Dear Ms Gibson,
RE: 1 Lawson Square Redfern 2016

We refer to your email of 10 February 2016 wherein you request further consideration and a response to the review by the Department of Planning and Environment to the Section 96 drawings (Issue C) lodged with the department on the 7 December 2015. You have requested that we provide a response to comments raised by both Russell Hand at the City of Sydney and additional matters raised by the Department of Planning and Environment.

DRAWING No.
SK - 04

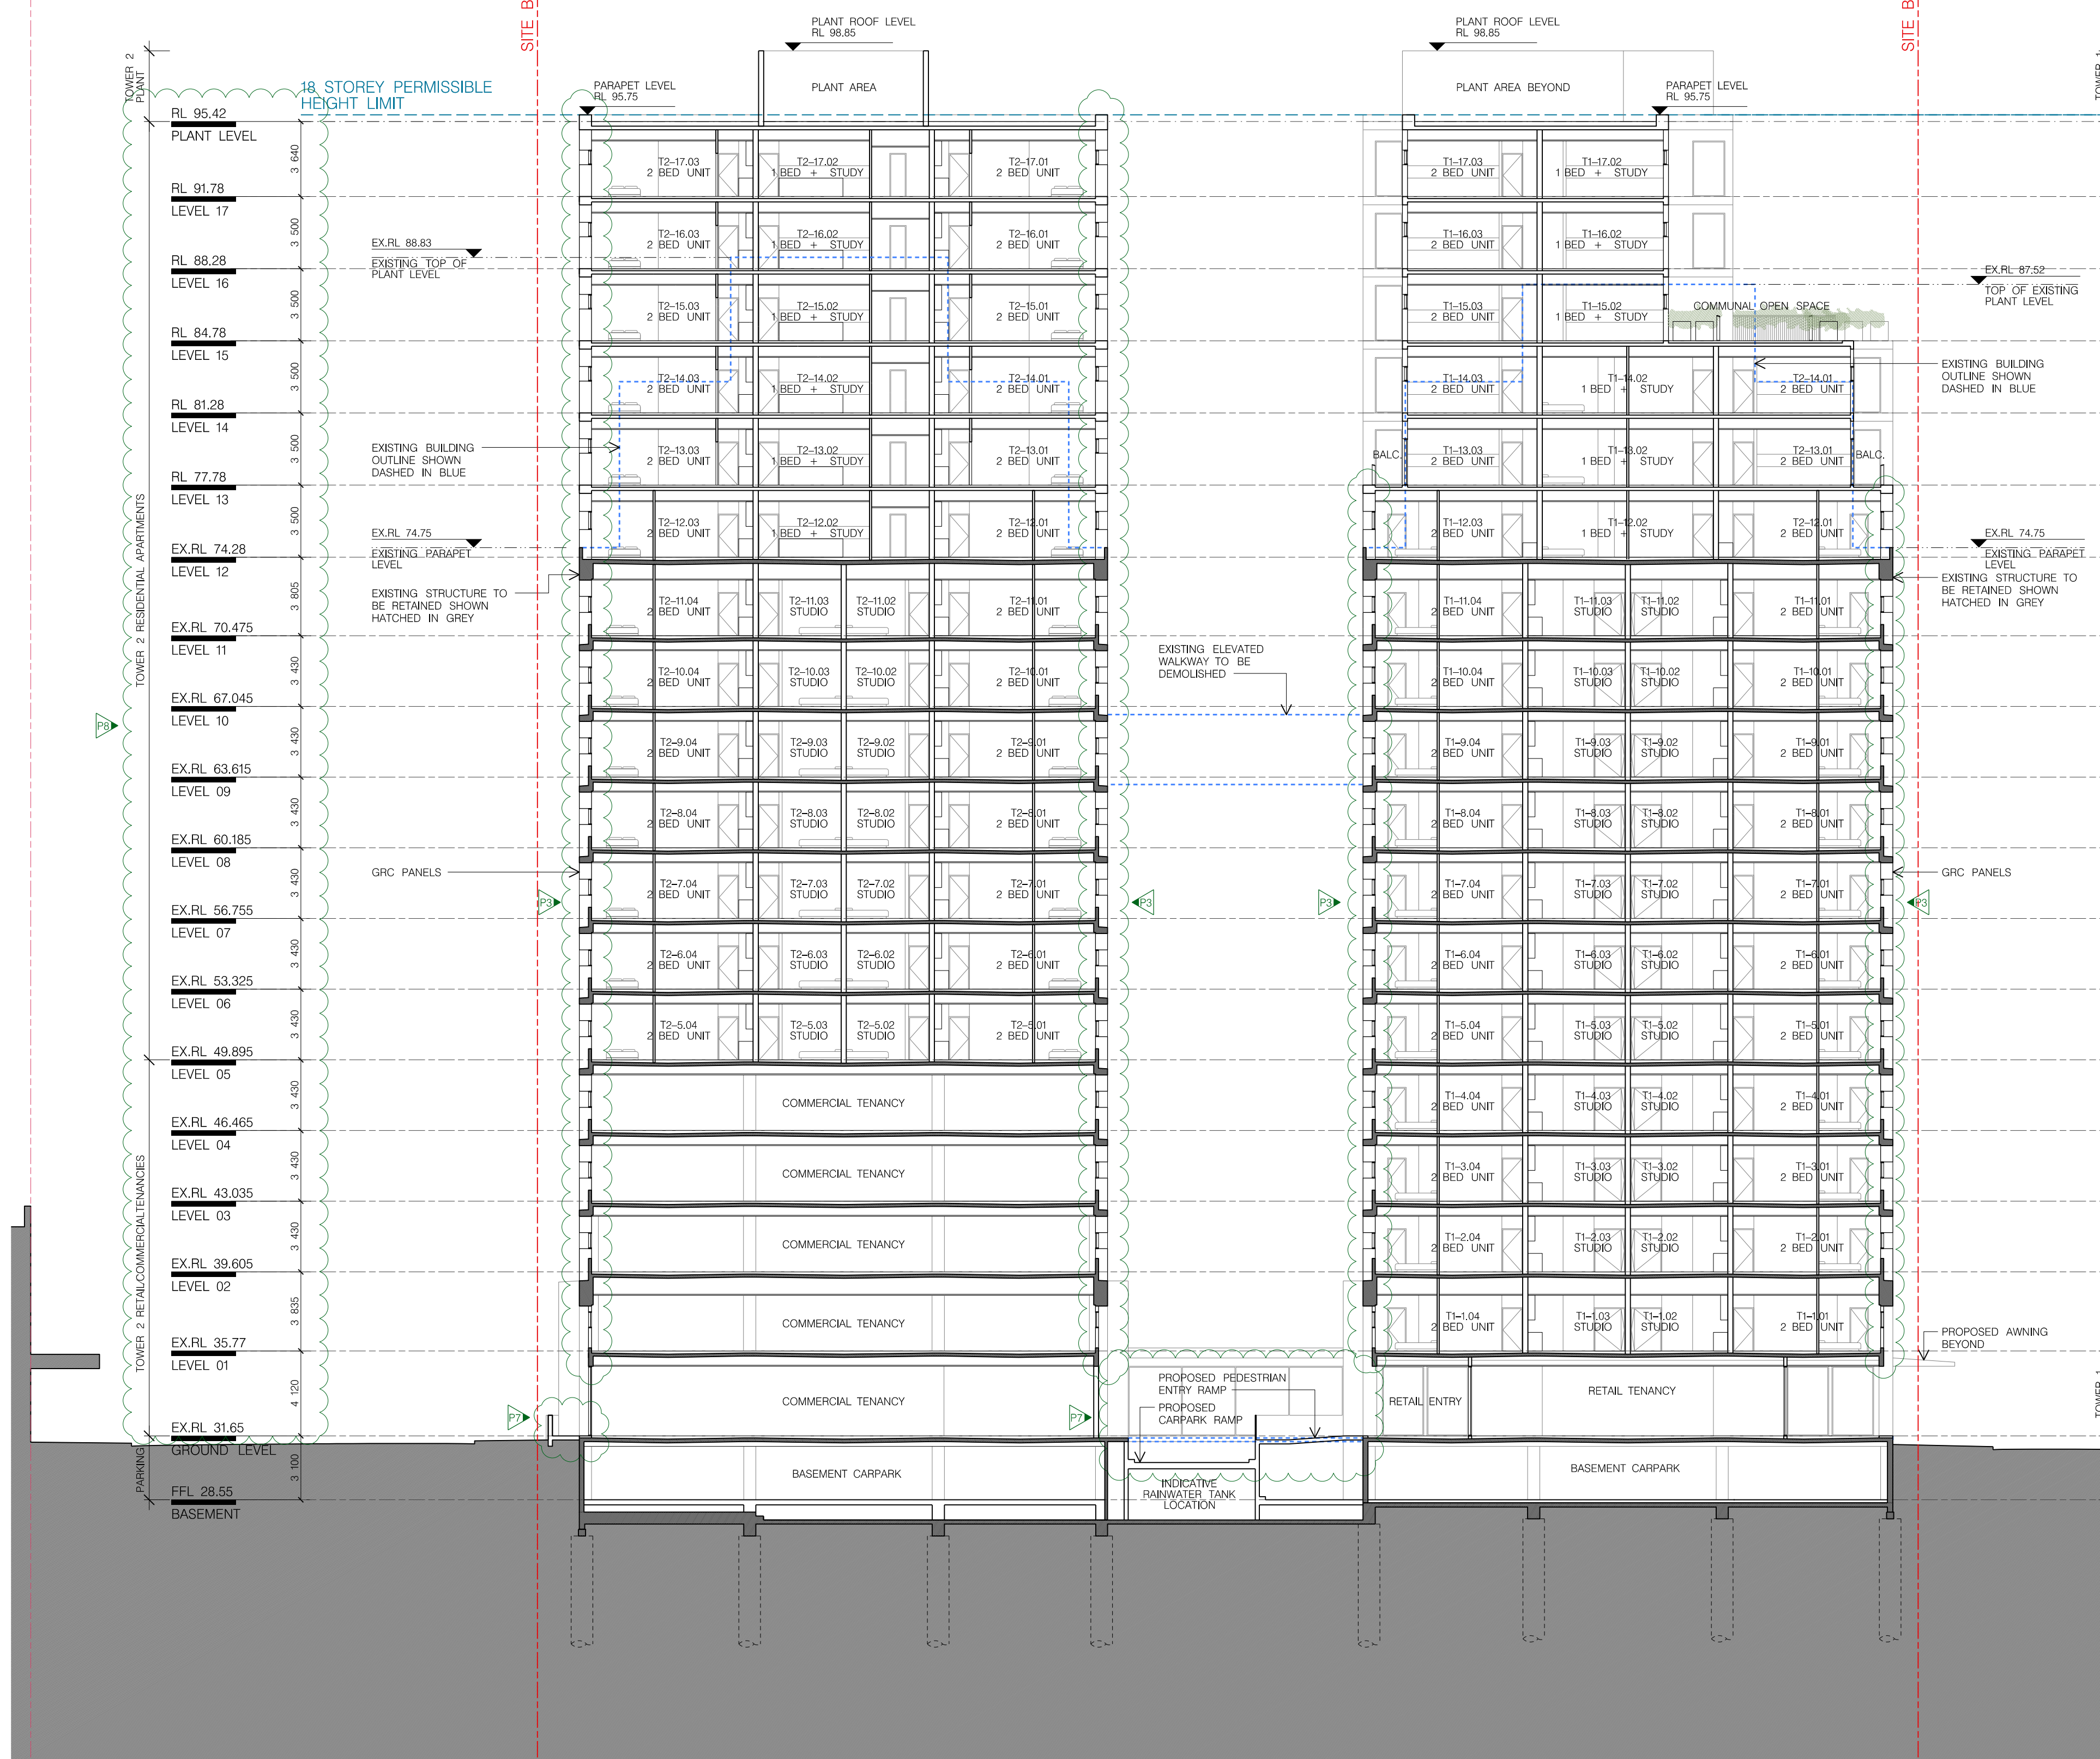
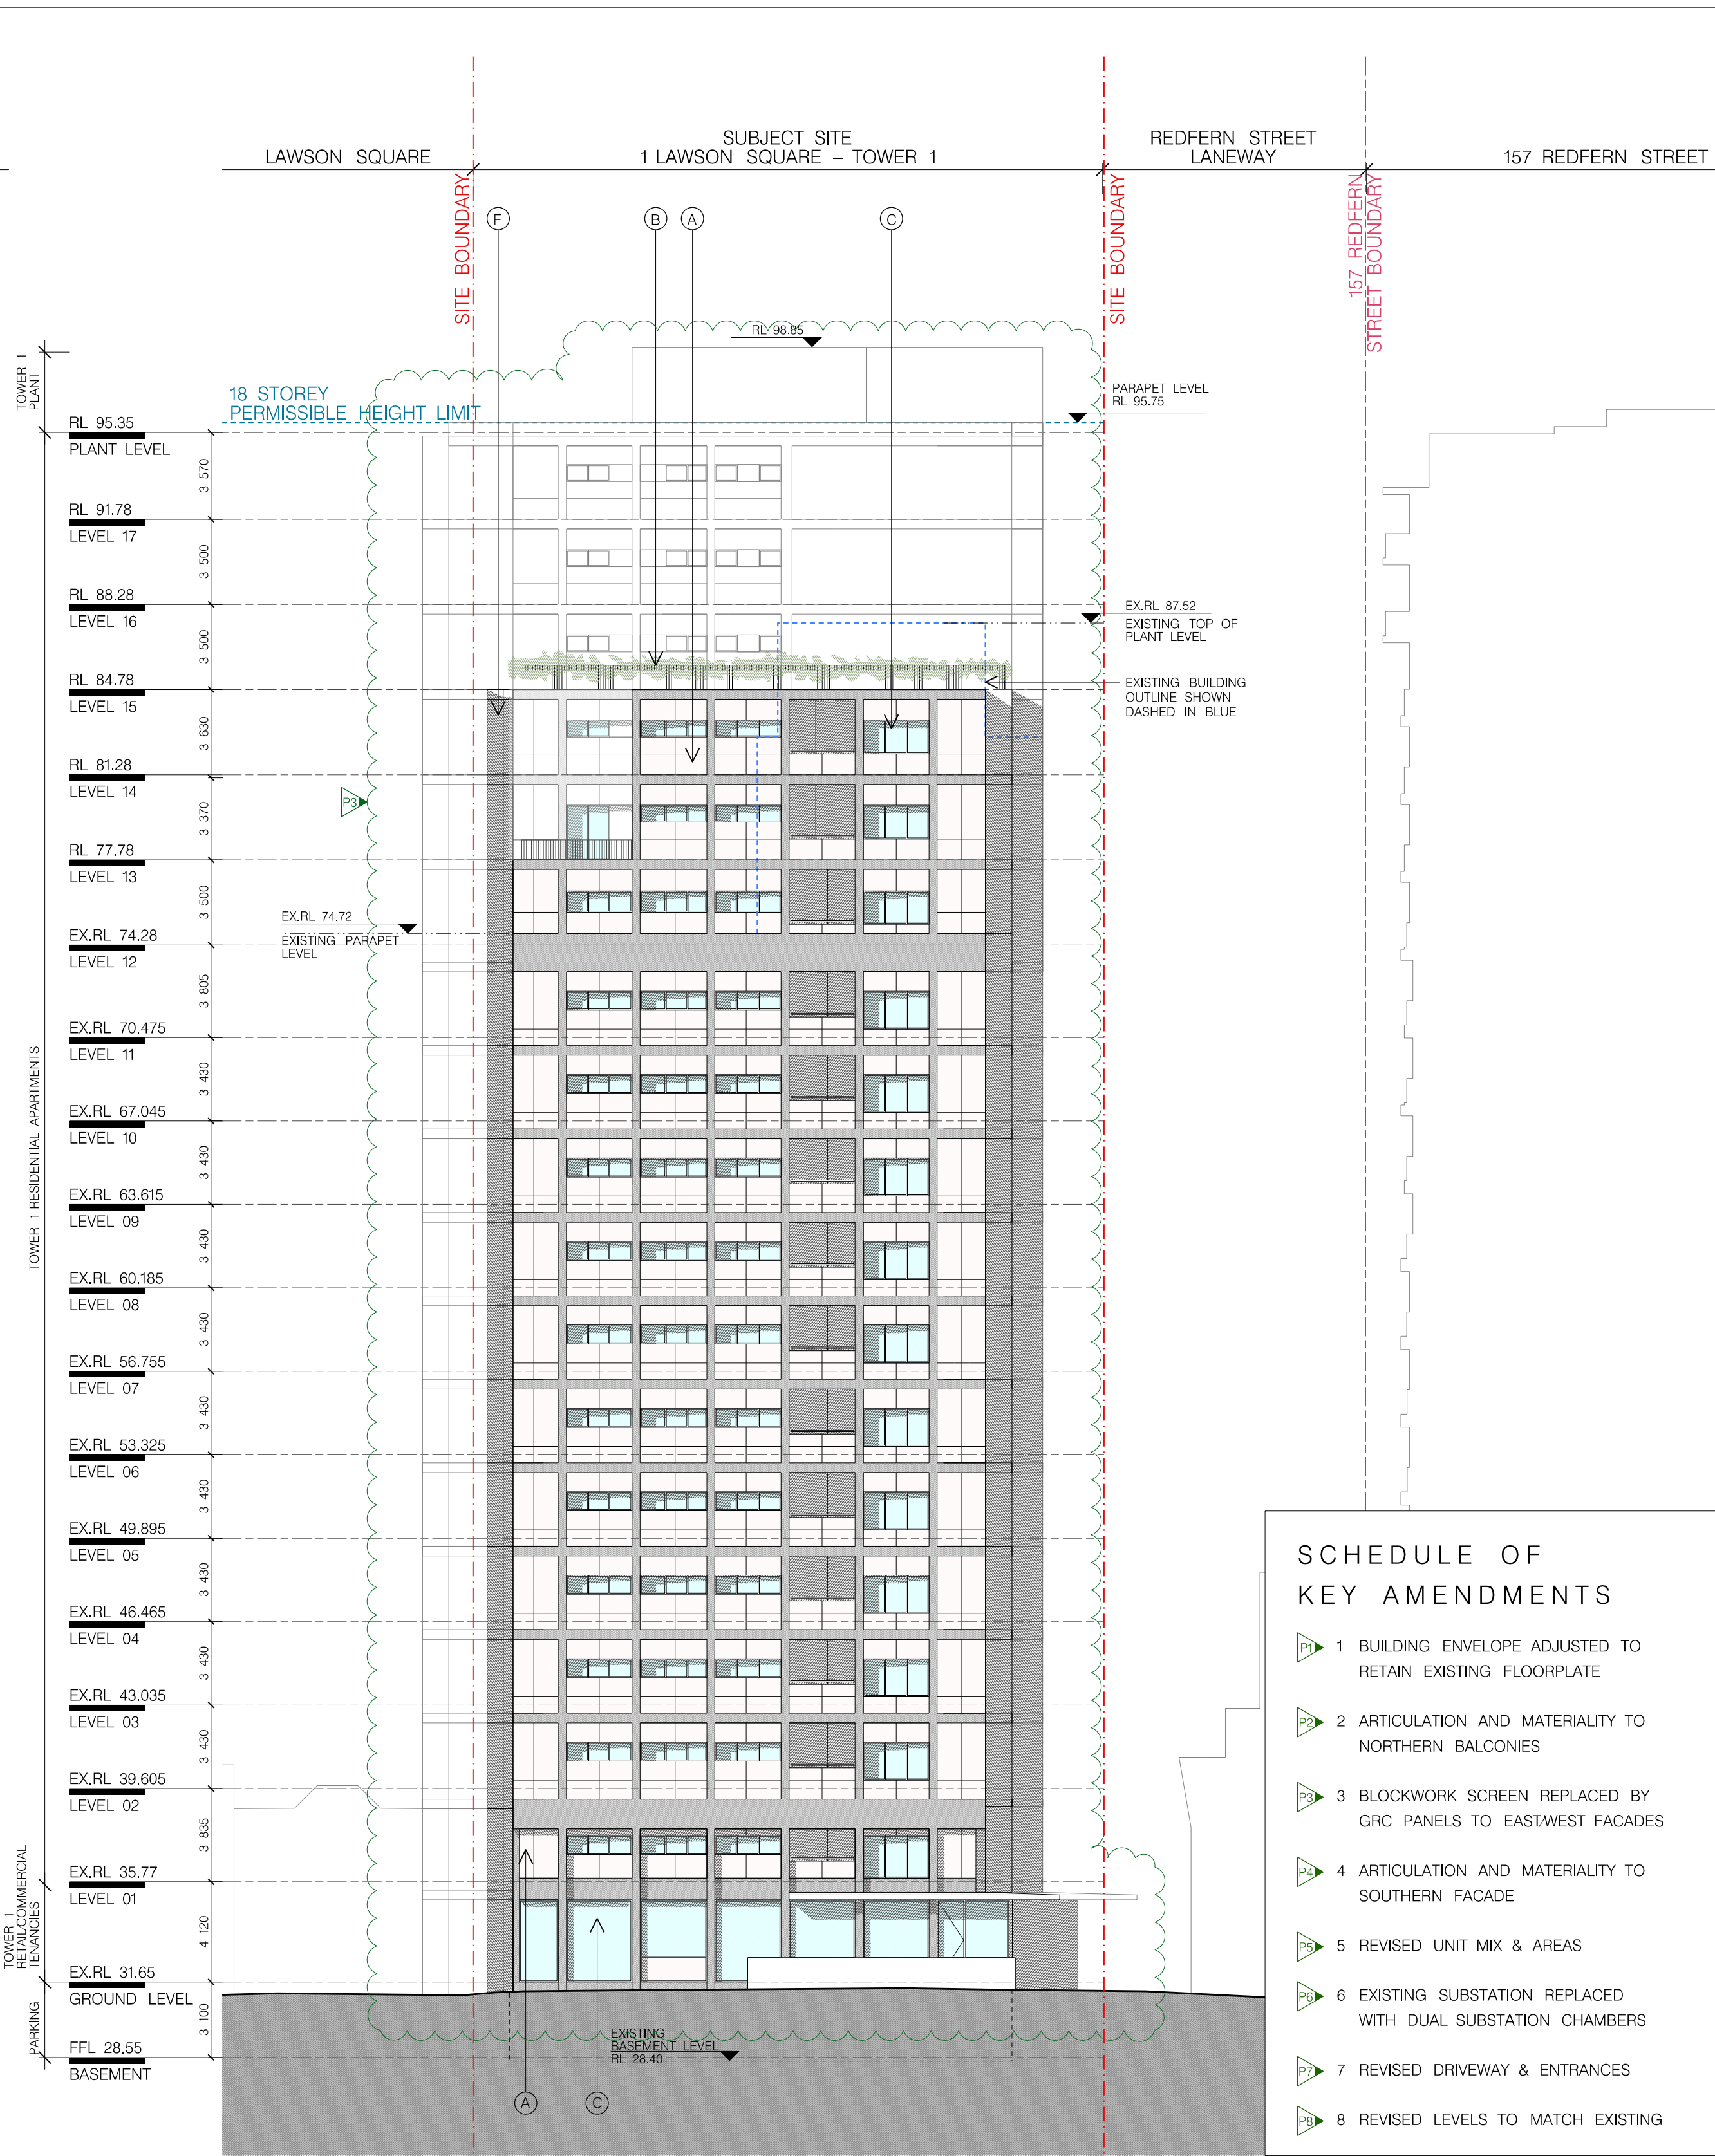
- 2. Northern balconies on both towers should remain an overhang of the building as opposed to the columns hitting the ground. The drawings call these columns "blade walls" despite their heavy appearance. The shape of the columns creates CPTED issues in that hollow recesses, alcoves and corners allow concealment opportunities and blocking of street surveillance. Lightweight blade walls that commence from Level 1 and above are favoured. An alternate appears to be tapering the profile of the columns where they hit the ground so that alcoves and concealment opportunities are minimised.*

4. *Justification for including pedestrian ramps within the future public domain is necessary. Although the ramps are within the site boundaries, building entries should be at grade and any level differences handled within the building. The new ramps at south-western corner of Tower 1 are particularly unresolved. There appears to be a high wall around the eastern retail ramp (as is evident in the photomontages) and an enclosed alcove around the southern residential ramp (evident in the elevations). Both of these create Crime Prevention Through Environmental Design (CPTED) issues in relation to concealment and should be deleted or reimagined in the scheme.*

5. *Reinstatement of a café or food premises tenancy along Redfern Lane between the buildings is desirable for activity and life along the laneway. In exchange for the proposed placement of substations along the lane, the proposal needs to compensate for poor activation. The longevity of the NSW Police using the reformatted commercial tenancy in Tower 2 is not guaranteed, along with the surveillance of the laneway this may create, both physical and perceived.*

Response: The ground floor/ public domain plan has been reconsidered to adopt the comments raised by the City of Sydney. The current 'hollow recesses/ alcoves' have been removed in lieu of glazing that extends to the perimeter of the building form. Please refer to drawing SK-04 for further detail.

Response: The pedestrian ramps within the public domain have been reconsidered throughout the proposal. The eastern and western pedestrian ramp have been removed in lieu of 'on grade' entry to the potential café on the south western corner and the lobby entry on the eastern façade. The northern entry ramp has been reconsidered to maximise building surveillance to the ramp from the future retail/ café tenancy. Please refer to drawing SK-04 for further detail.

Response: Despite the financial advantages of having the proposed substations sitting side by side, they have now been placed in different locations to minimise poor street activation in the laneway. As suggested, the possible café entry has now been located on the southwestern corner with on-grade entry for an improved urban design outcome. Please refer to drawing SK-04 for further detail.
